**CHARLOTTE-MECKLENBURG
 PLANNING COMMISSION**

SUBJECT: Administrative Approval
 For Petition #88- 36 Carmel Investment Group

Rezoning Plan • Petition No. 88-36
Nations Ford Road Site
 Charlotte, North Carolina
 Carmel Investment Group/Hebron

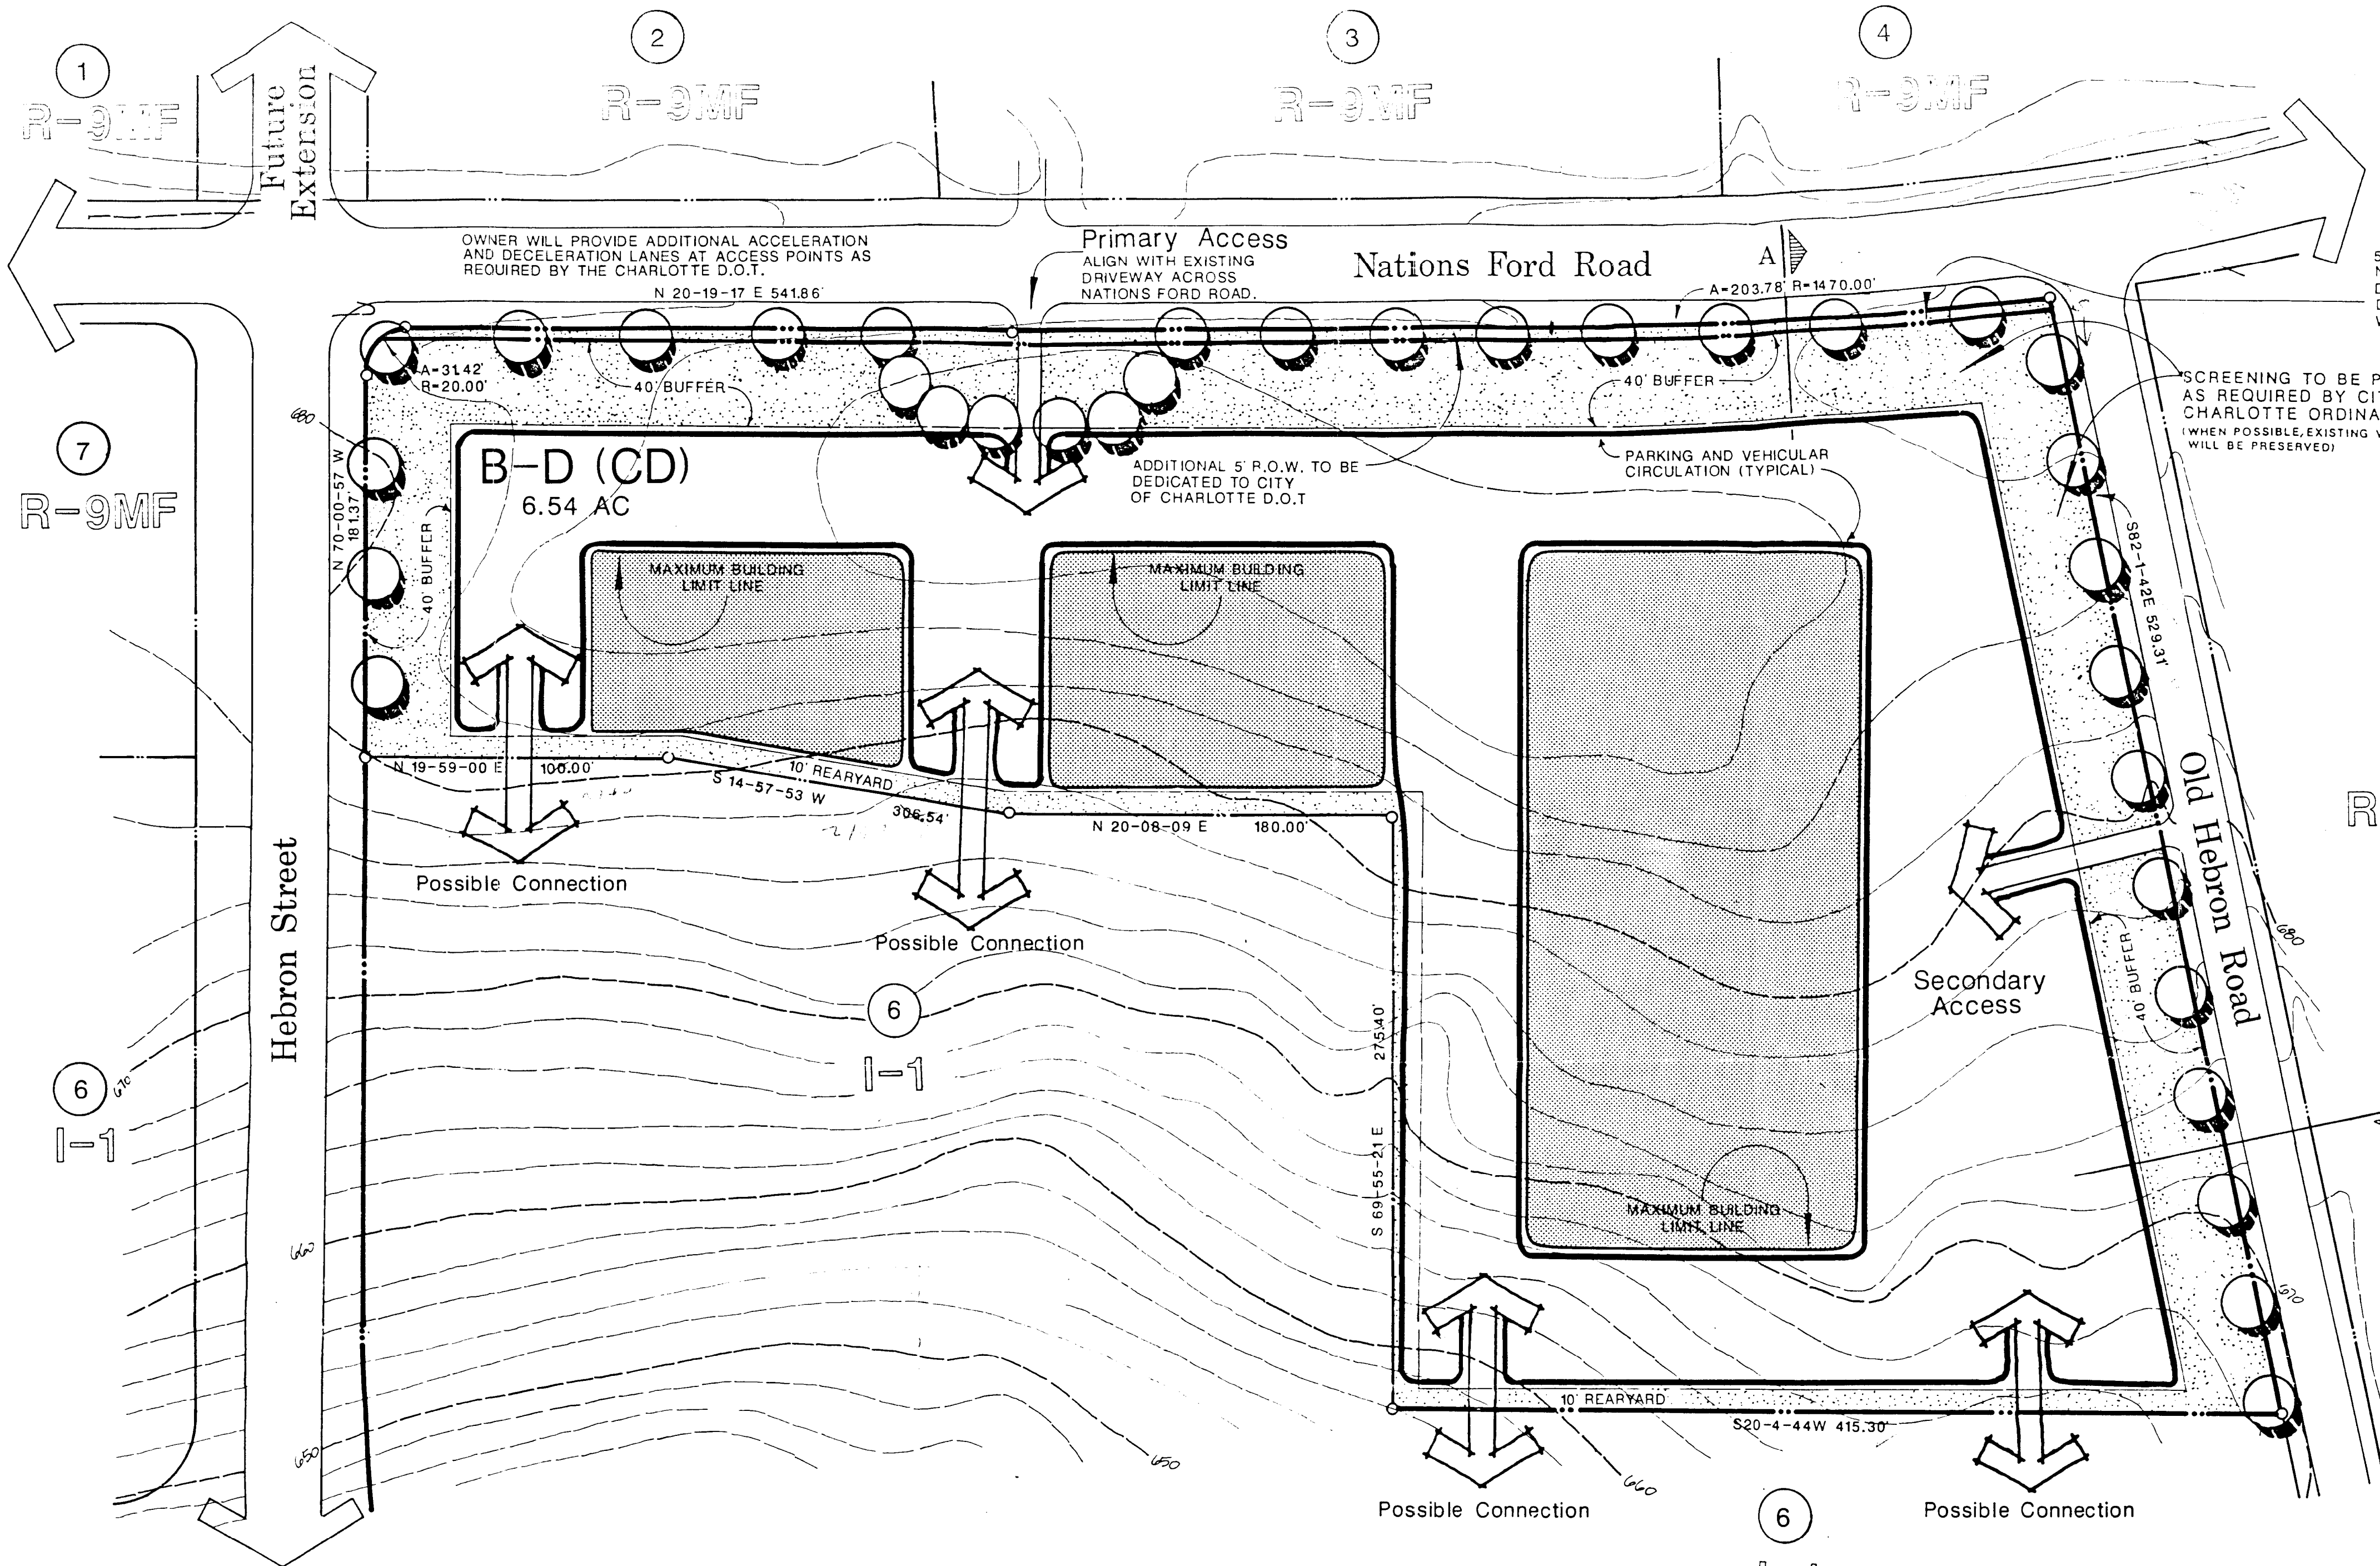
Attached is a revised site plan for the above referenced petition. The plan has been revised to delete a building area and reduce the size of an accompanying area. Consequently the maximum square footage for the site has been reduced to 47,500 sq. ft. The areas shown as building areas have been redesigned for parking. Since the building areas have been converted to parking, to serve a building on an adjoining parcel, an additional driveway has been allowed. Since these changes represent a less intense use of the site, I am administratively approving these changes. Please use this site plan when evaluating requests for building permits.

Attached is a revised plan for the above referenced petition. The plan has been revised to show new building limit lines, and a reduction in the maximum building area. Since these changes represent a less intense use of the site, I am administratively approving this plan. Please use this site plan when evaluating requests for building permits.
